2 September 2016

RE: Request for Comment - Glendell Mine Modification 3 (DA 80/952 MOD3)

Figure 2: Proposed transmission line alignment

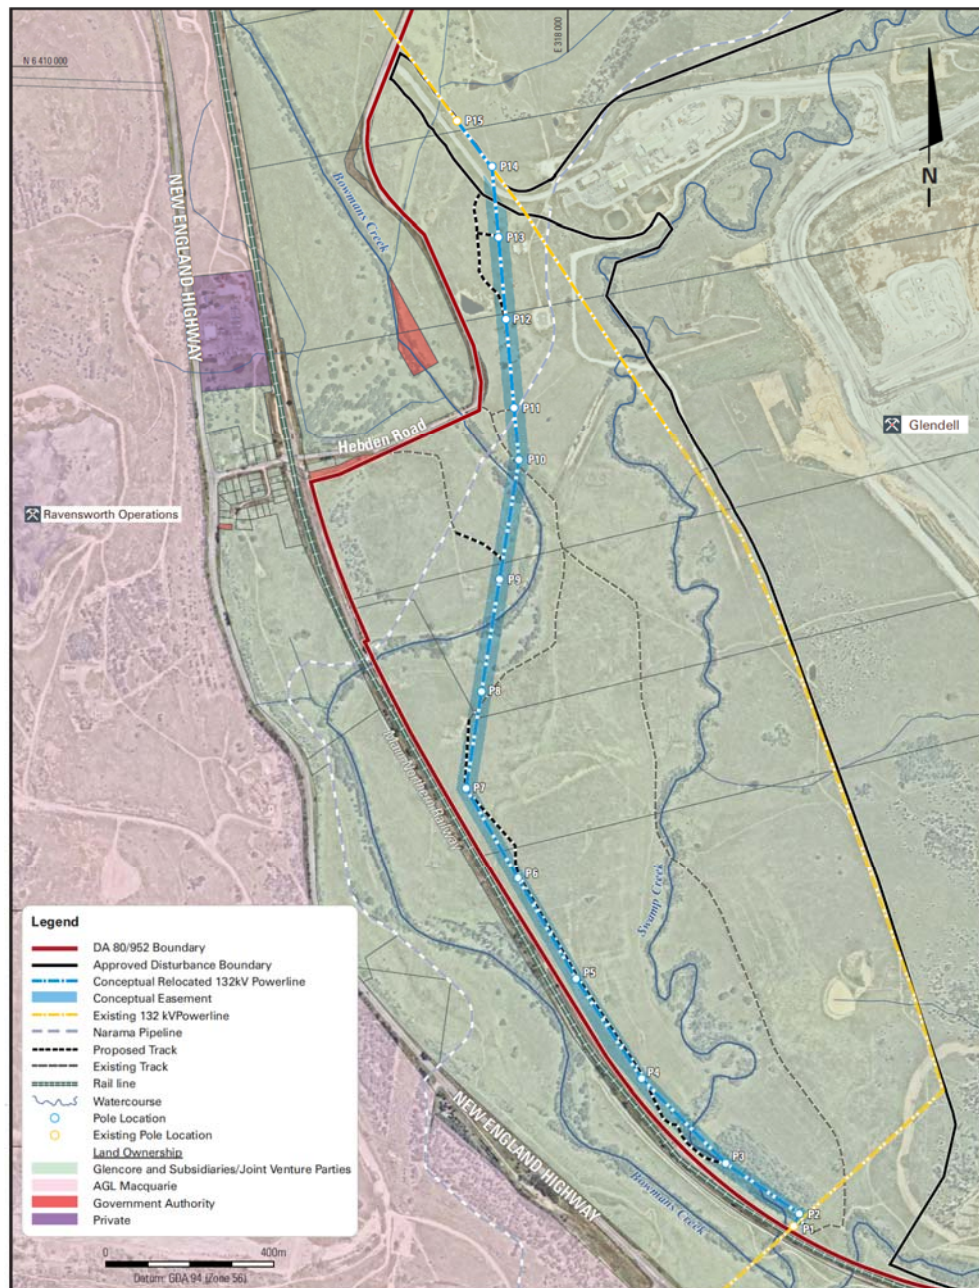
1. The 132kV relocation is identified as being within the approval boundary but outside the disturbance boundary for the mine's approval. We note that this has been identified and would suggest some clarification on the impact this has on the environmental arrangements, assessments and approvals is included in the documentation.

2. The use and impact of access tracks for the modification appears to lack detail. We note that the proposed access arrangements provided to Ausgrid in the proposed design (sheet 19), include access to poles being through the 132kV easement for the majority of the route. This appears to include access through swamp creek. As Ausgrid requires the access tracks to provide 24/7 all-weather access to the proposed poles, it is assumed that additional access works through swamp creek will be required but do not appear to have been assessed. Ausgrid intends under operations and maintenance conditions to only access these poles via rights of way and easements established as a part of the proposed project.

3. We note that the assessment indicates the selected location of poles is a "substantial" distance from the Bowman and Swamp Creek areas (section 4.3.2) although this distance is not defined. Poles 1, 2, 3 and 10 on the route appear to be in close proximity to Bowman's and Swamp Creek. Ausgrid suggests additional detail may be required to confirm this still meets the definition of a substantial distance from these areas and that these poles will not affect sensitive areas along the route.
